Subject: Butlins Upper Bognor Road Bognor Regis PO21 1JJ - BR/307/20/PL

Planning Application Reference: BR/307/20/PL

Proposal: New reception kiosk and alterations to car park layout. This application is in CIL Zone 4 zero rated as other development.

Address: Butlins Upper Bognor Road Bognor Regis PO21 1JJ

Bognor Car Park Works Proposed Site Plan

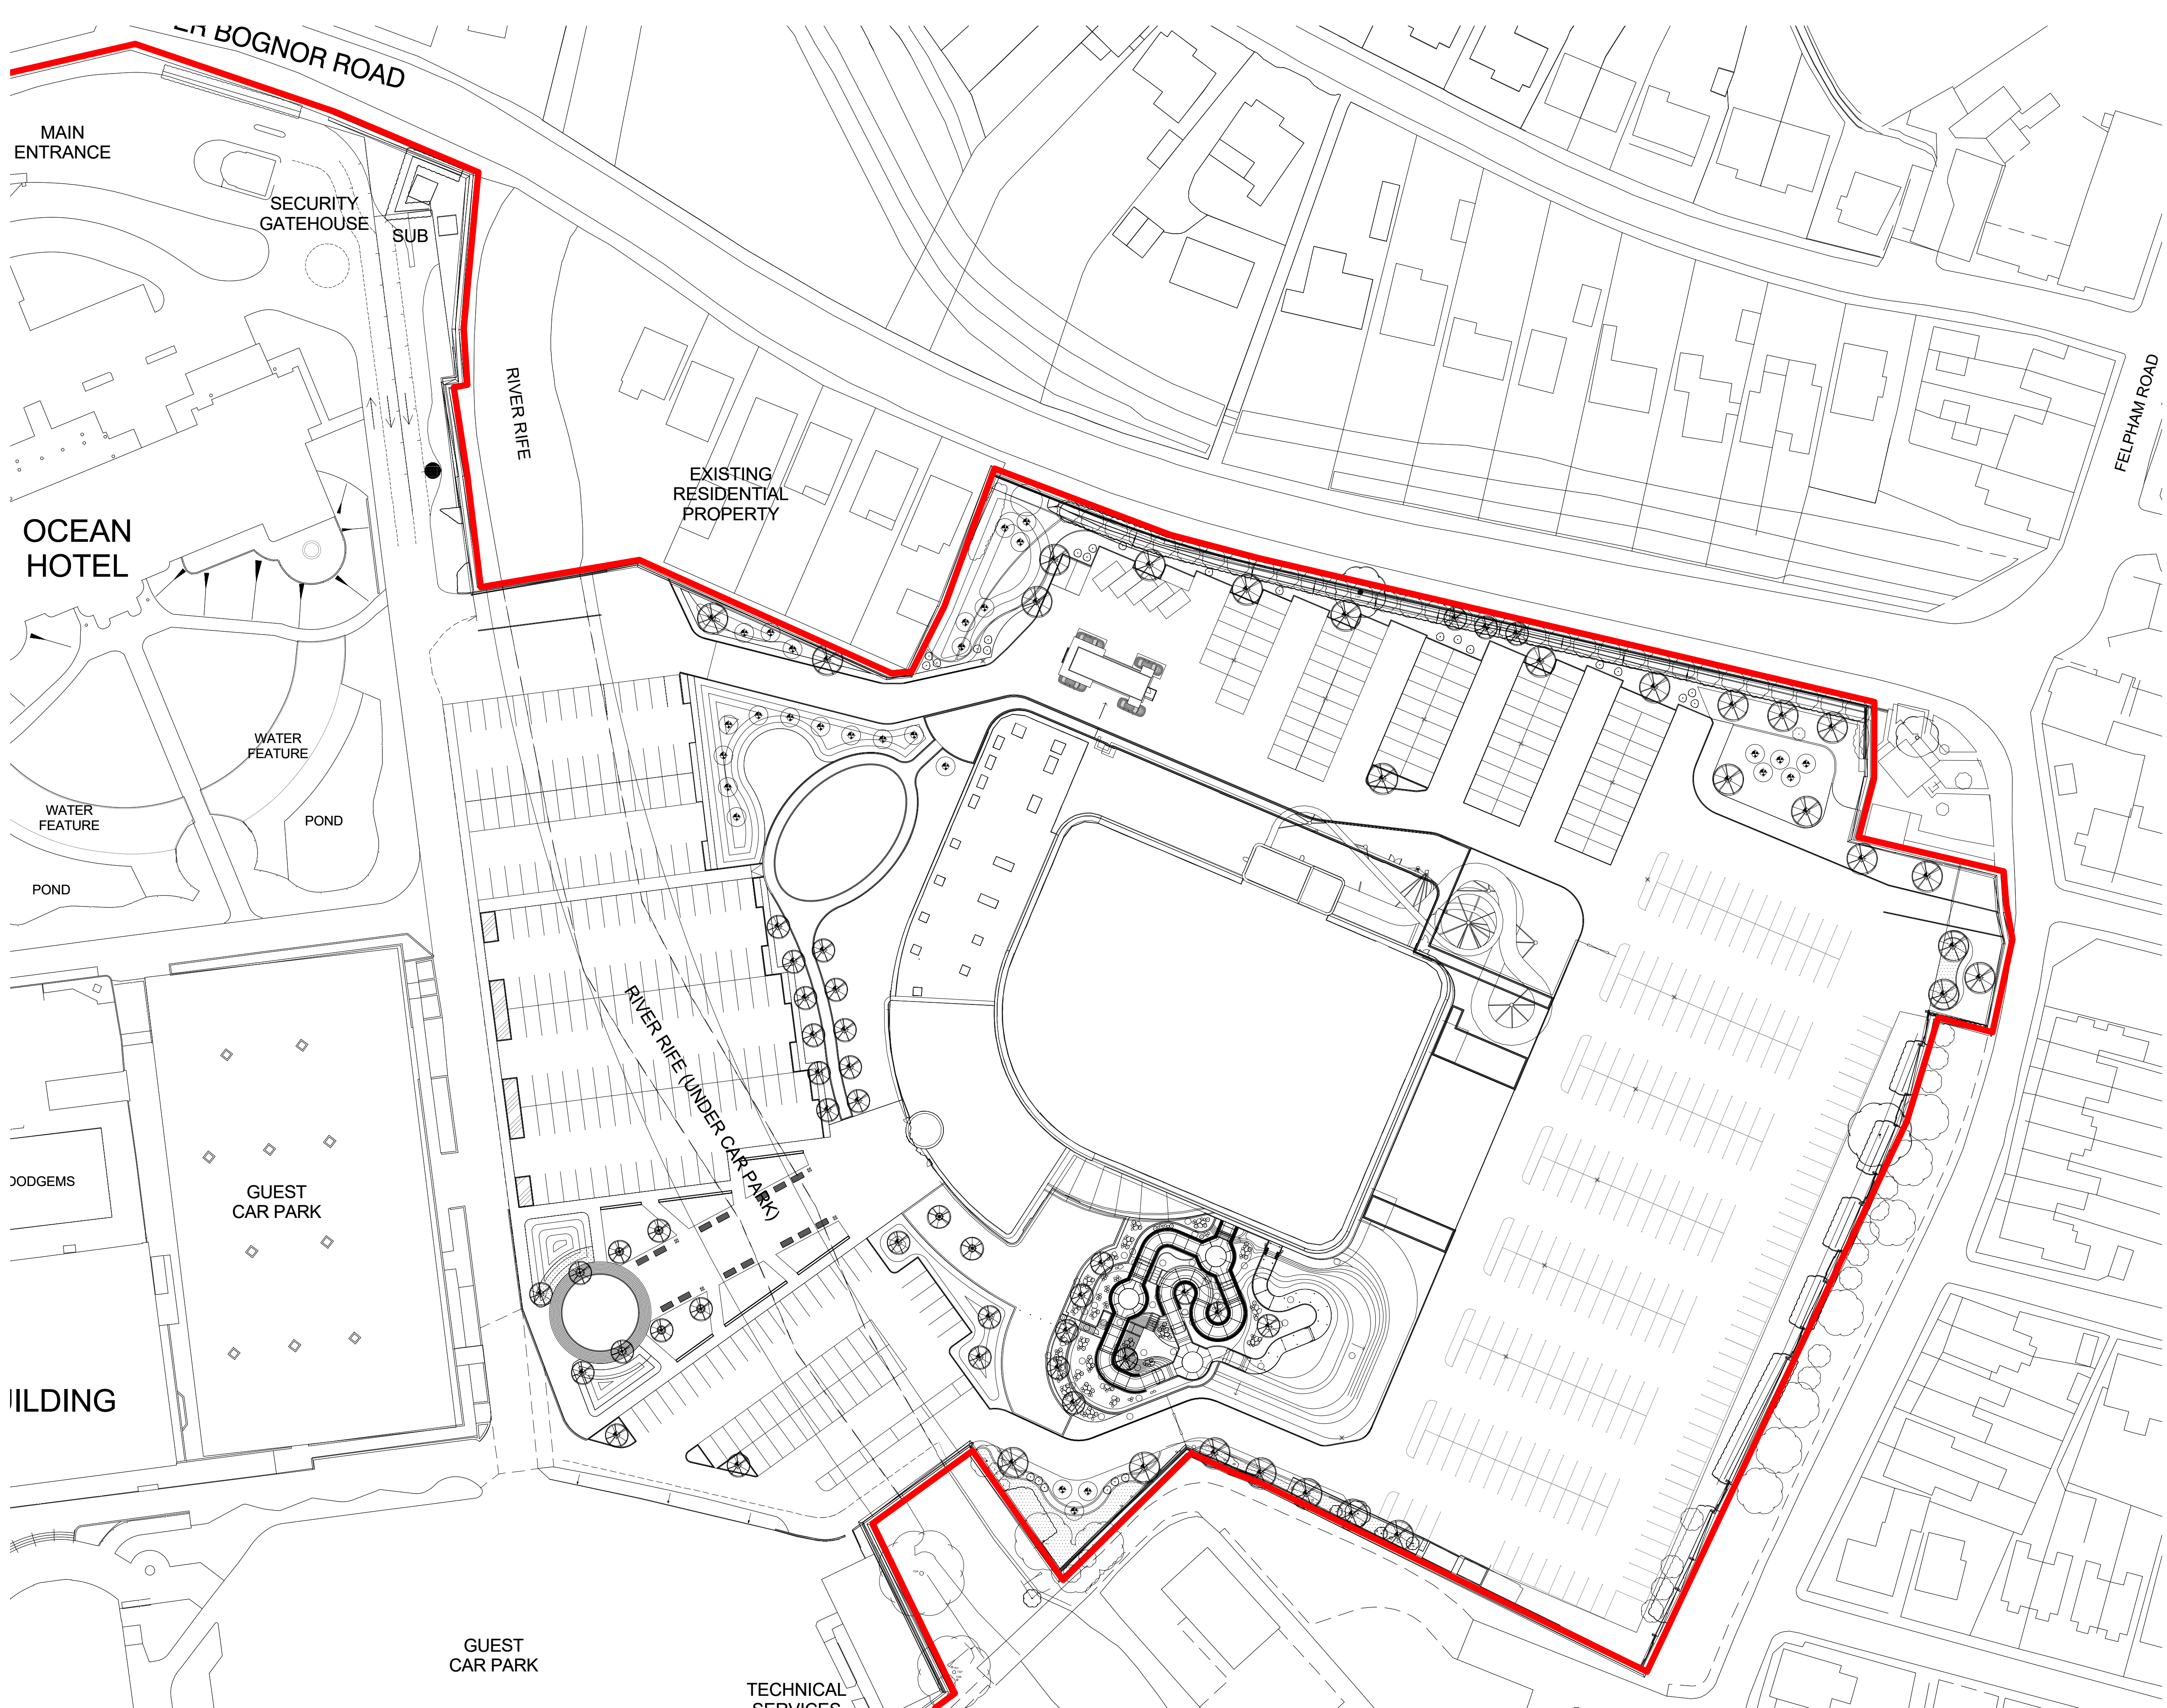
Further to my previous comments - impacts of noise and air pollution from vehicles queuing to enter the site must be considered. Whilst I acknowledge an existing acoustic fence has been installed on the perimeter of the residential premises' adjacent to the proposed queueing area; I feel there remains a potential for detrimental impact on the amenities of the locality brought about through noise and air pollution from traffic queuing to enter the Butlin's site.

I therefore recommend the proposal be granted a temporary permission for the duration of 24 months to allow for assessment of the impacts from noise and air pollution on the amenity of the locality.

The applicant shall be required to submit a Noise Management Plan in writing for approval by the Local Planning Authority, to control noise emitted from vehicles/patrons queueing to enter the site. The Plan should make consideration for noise from car stereos, car engines, people noise and any other identified potential noise sources associated with the queue for the kiosk.

The applicant shall be required to install Nitrous Oxide monitoring stations at locations agreed by the Local Planning Authority to gather baseline data for existing Nitrous Oxide levels. The monitoring stations shall remain in situ for a minimum period of 48 months with data being collected on a monthly basis to be submitted to the Local Planning Authority annually. The applicant shall then complete an Air Quality Assessment to include recommendations for mitigating Air Quality impacts. The recommendations shall be implemented and maintained thereafter.

An informative should also be attached to any permission granted to encourage non-idling of vehicles whilst queueing and for Butlin's to have signage at the main entrance and at intervals along the queue to this effect.
